Application number: 2025/91944	
What is the application for?:	Erectio of single story rear extension and car parking to the rear
Address of the site or building:	Londis, 28-30, Leeds Road, Birstall, Batley, WF17 0EW
Postcode:	LS169JU

Type of comment: An objection	
Do you wish your comments to be published on the website anonymously?	No

Level 0
1 : 50

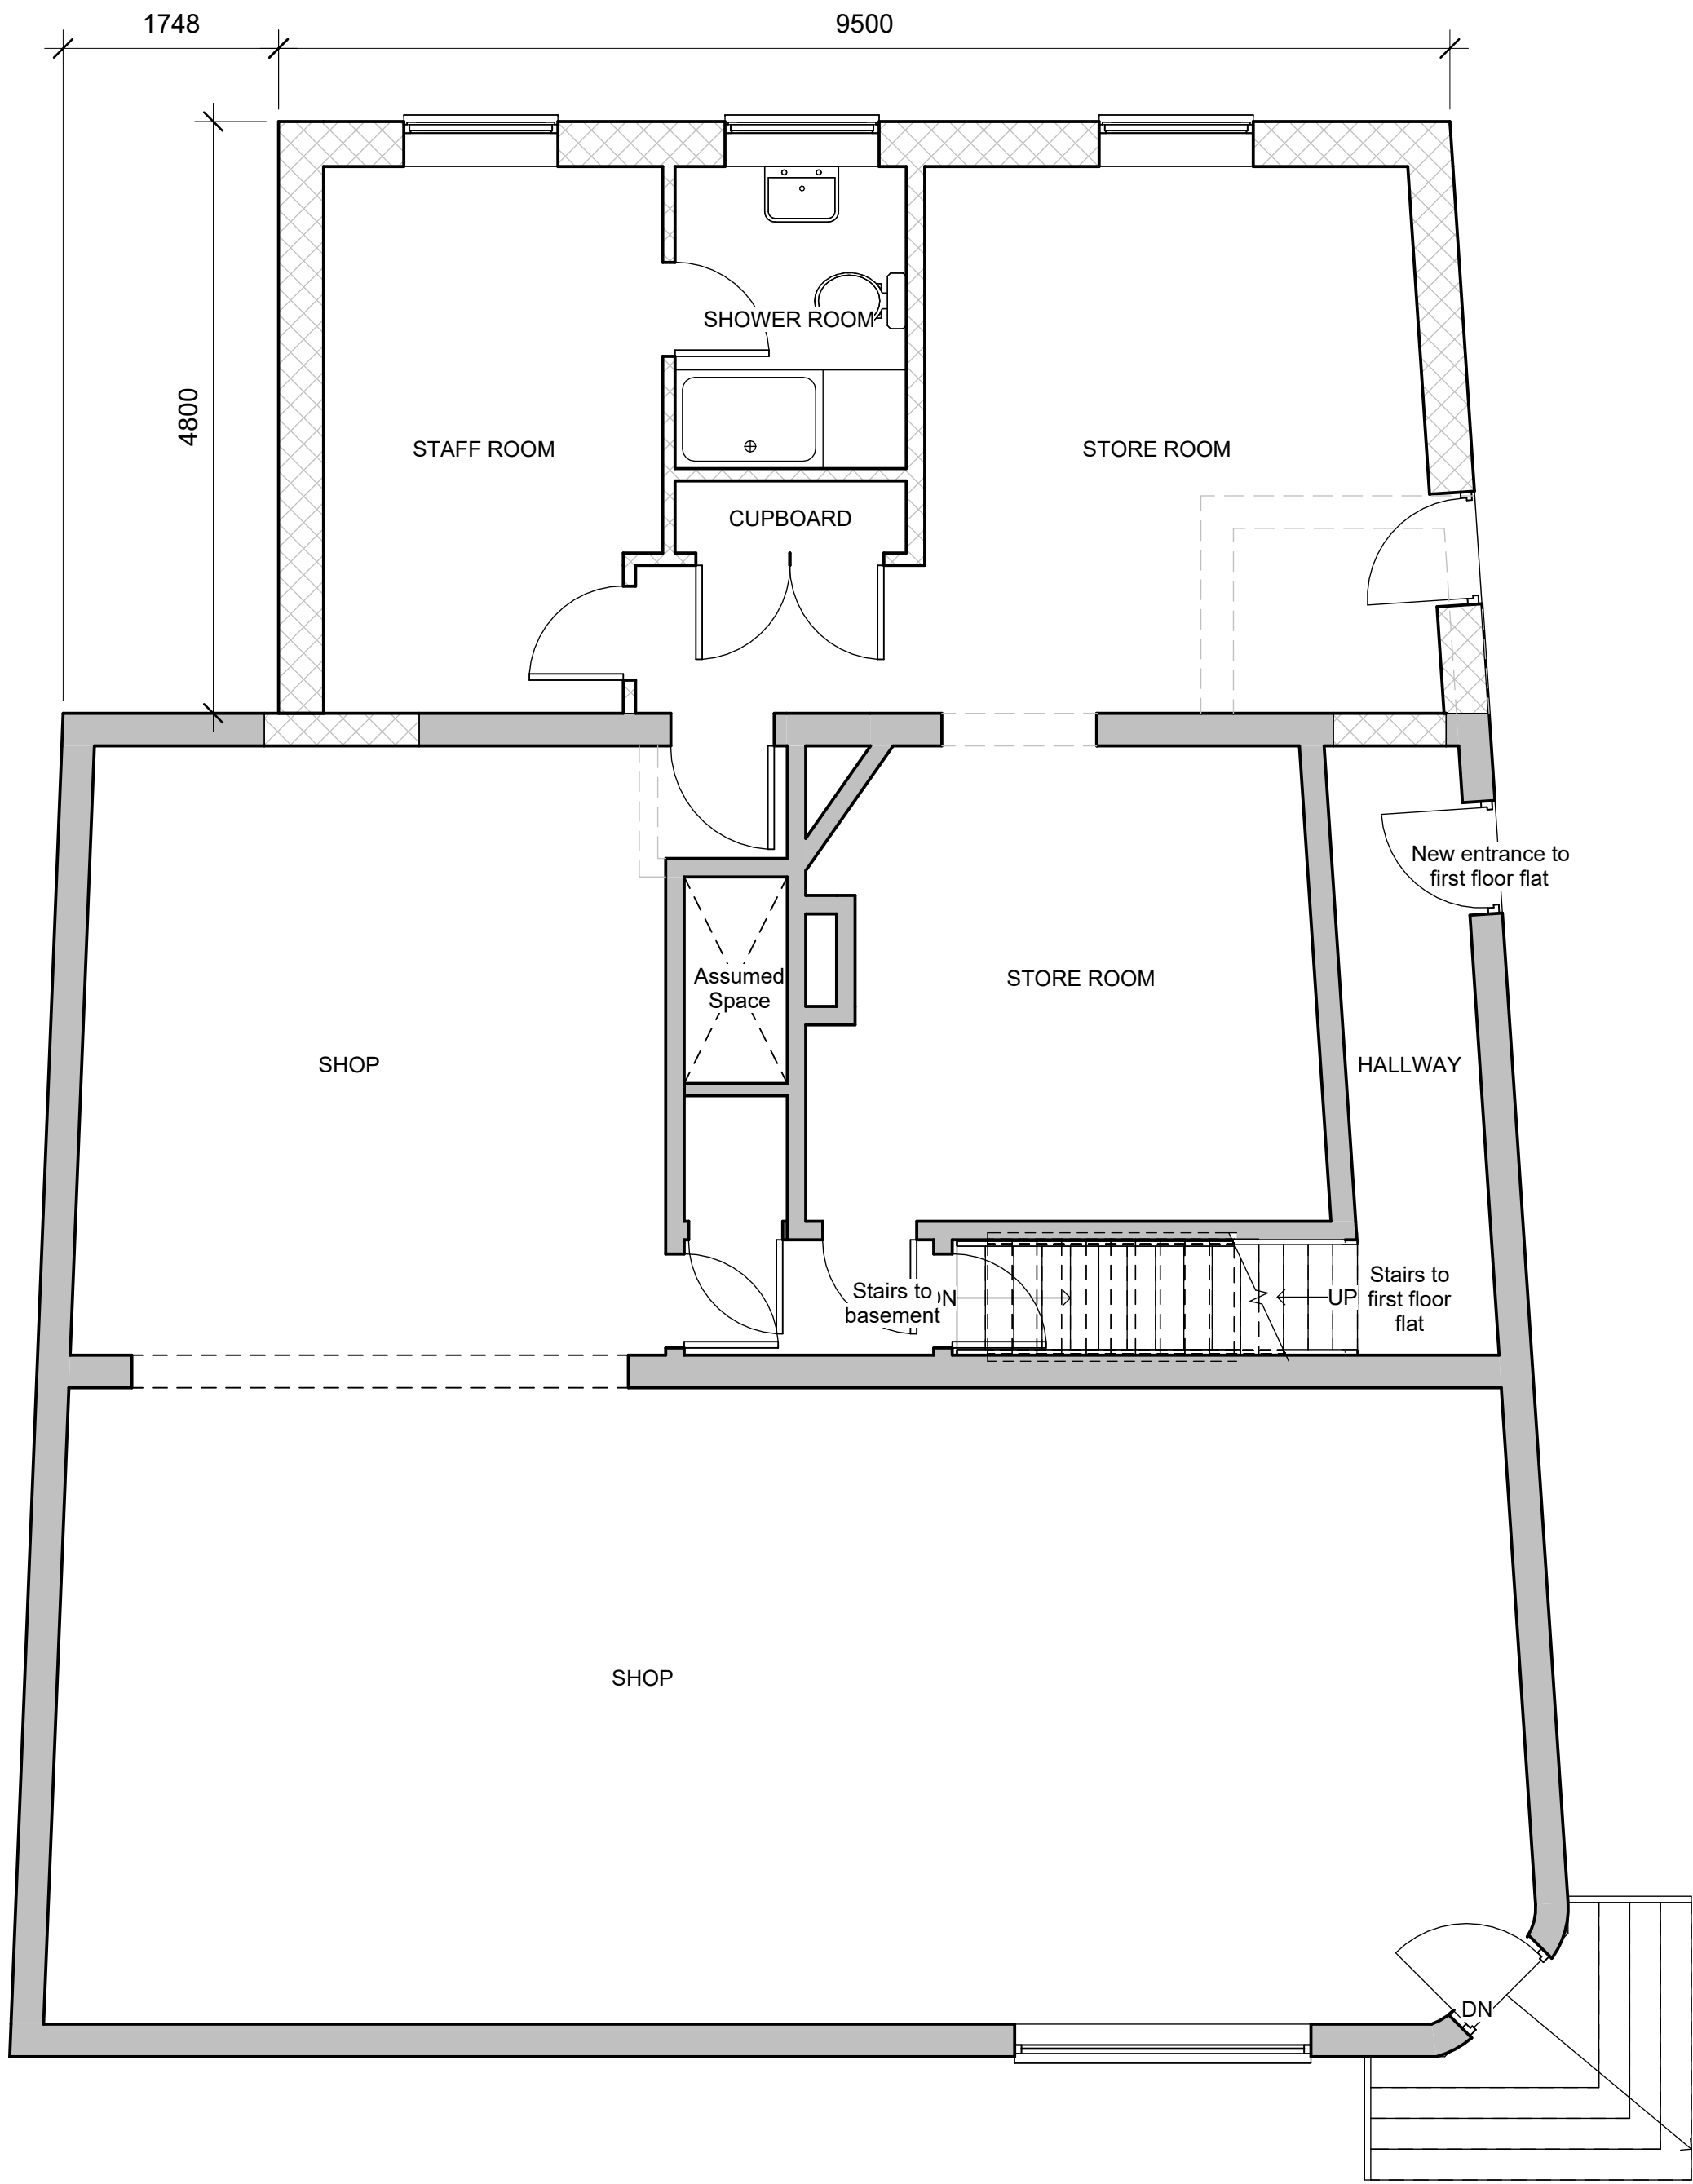
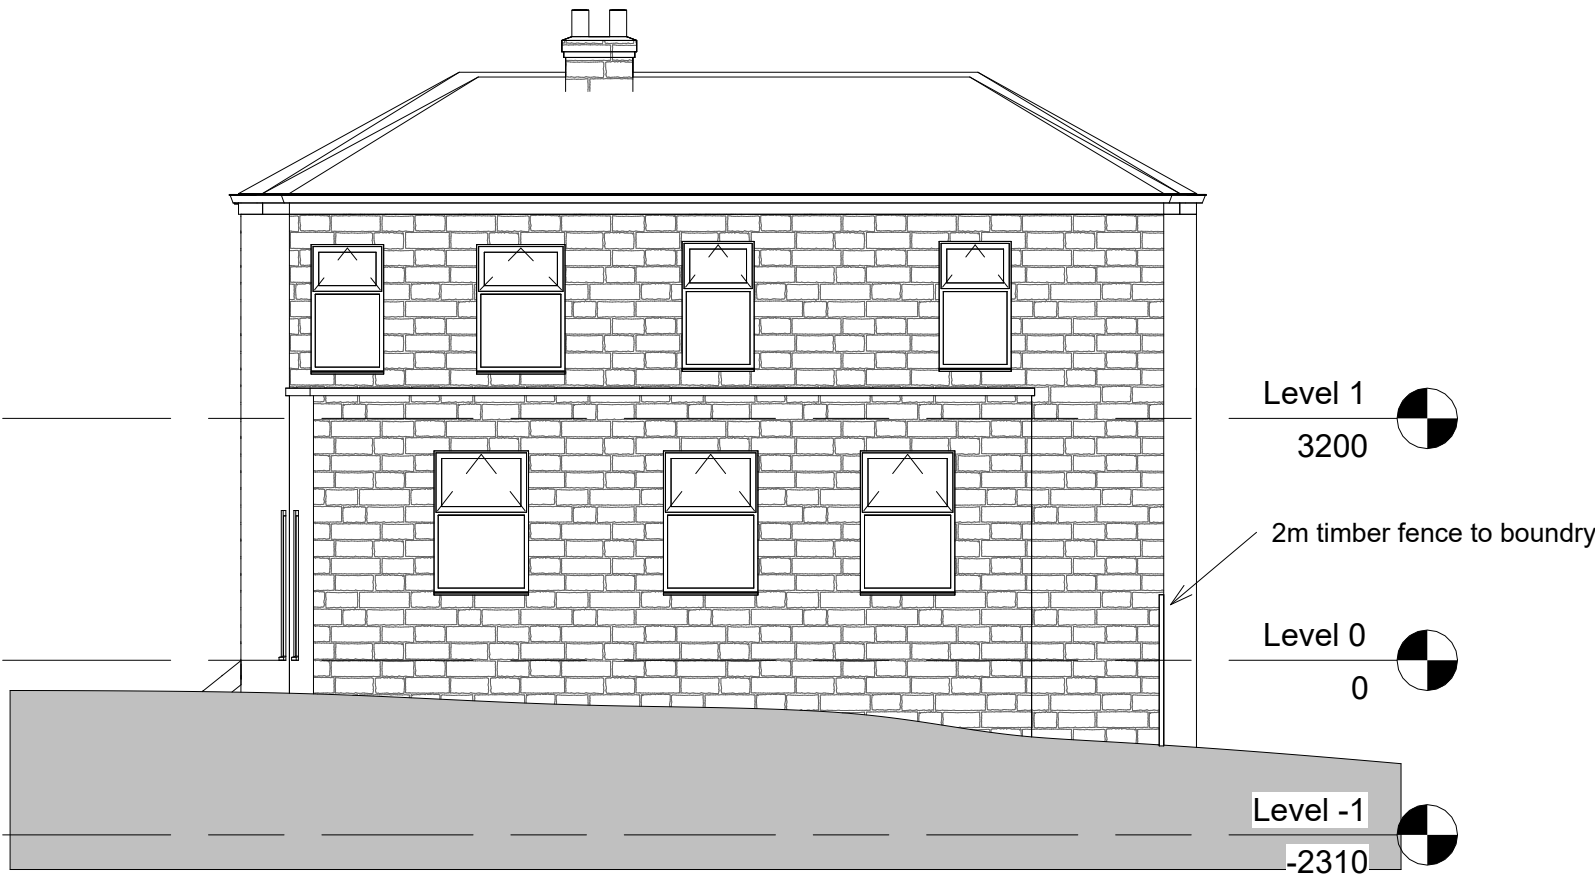
Looking at the plans, I question why the shop needs more store rooms, a staff room and a shower when over the decades, previous shop owners have managed very well, being far busier and better stocked than this Londis store has ever been. Having worked in the shop under previous owners I am very familiar with the inside of the property!

The shop owner has previously put in a planning application for two units building in the back yard. The reason was never disclosed and withdrawn after many objections from local residents. We strongly suspected the plans were to open fast food take-away units. I suspect this application if granted may lead to something similar. Why does this shop with very few staff need a staff room with a shower?

Site Plan
1 : 200

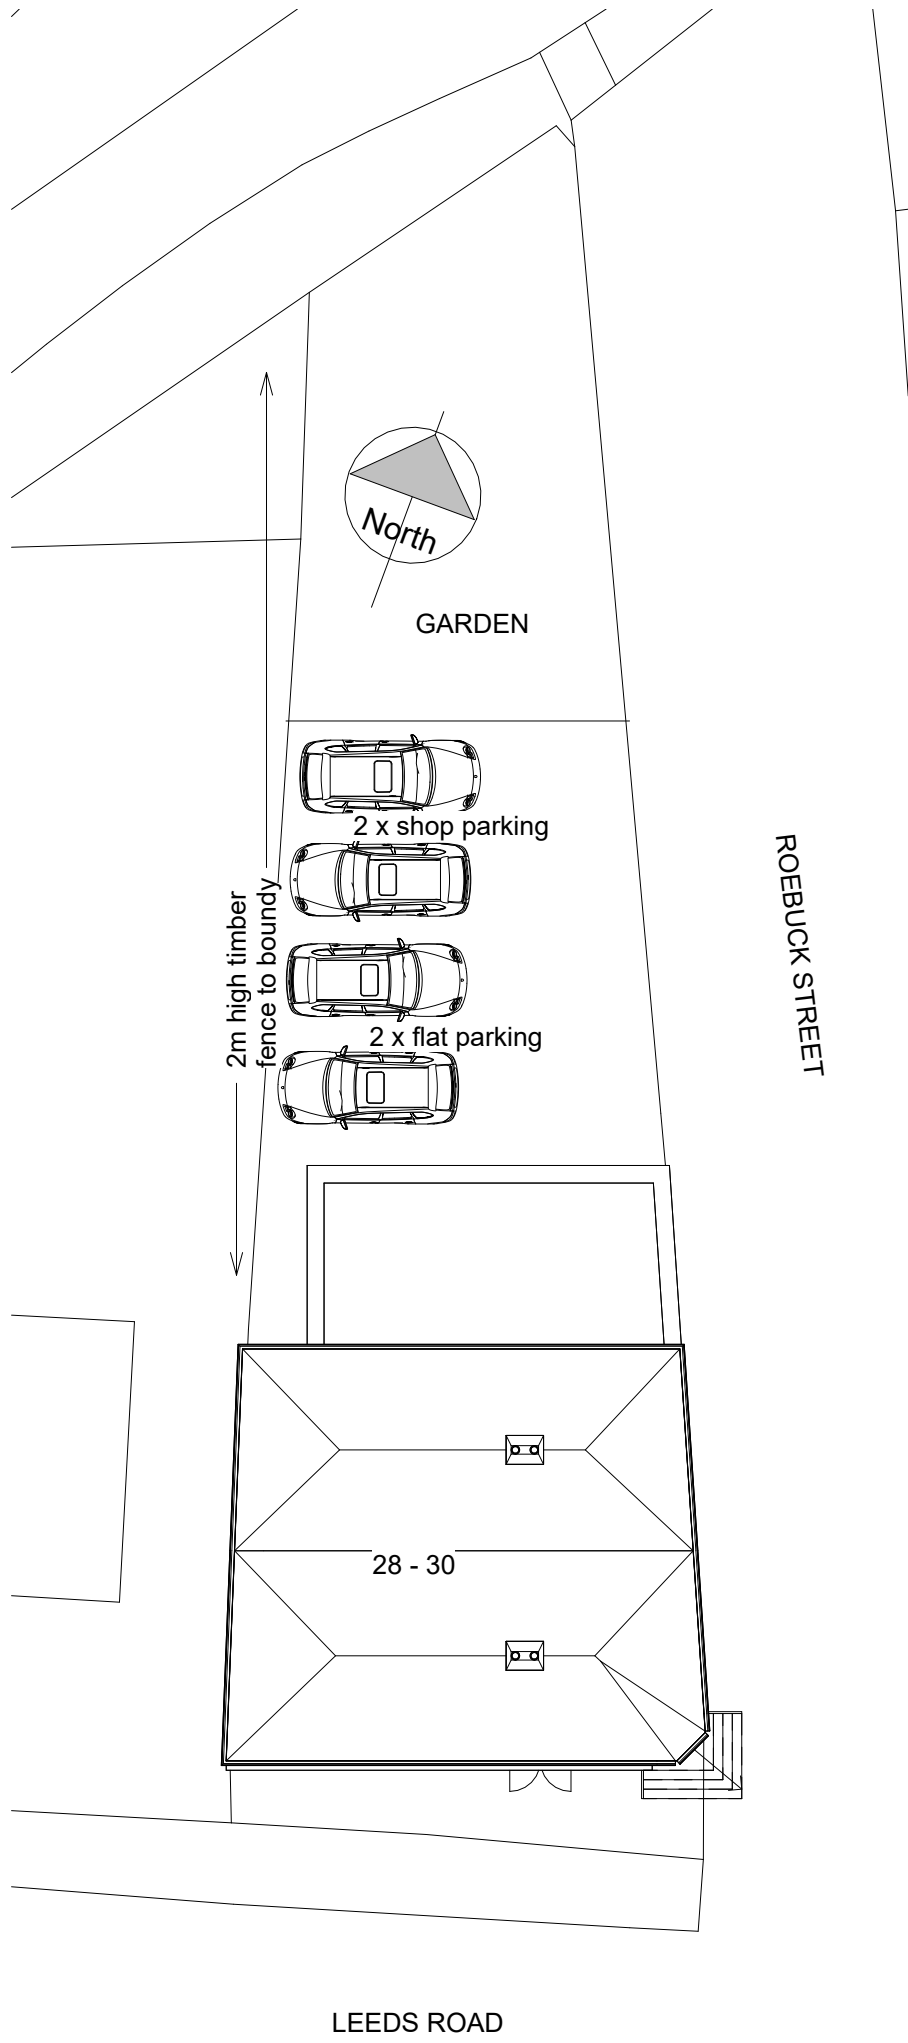
The plans include parking areas. There is already plenty of space for car parking at the rear of the shop which is rarely used.
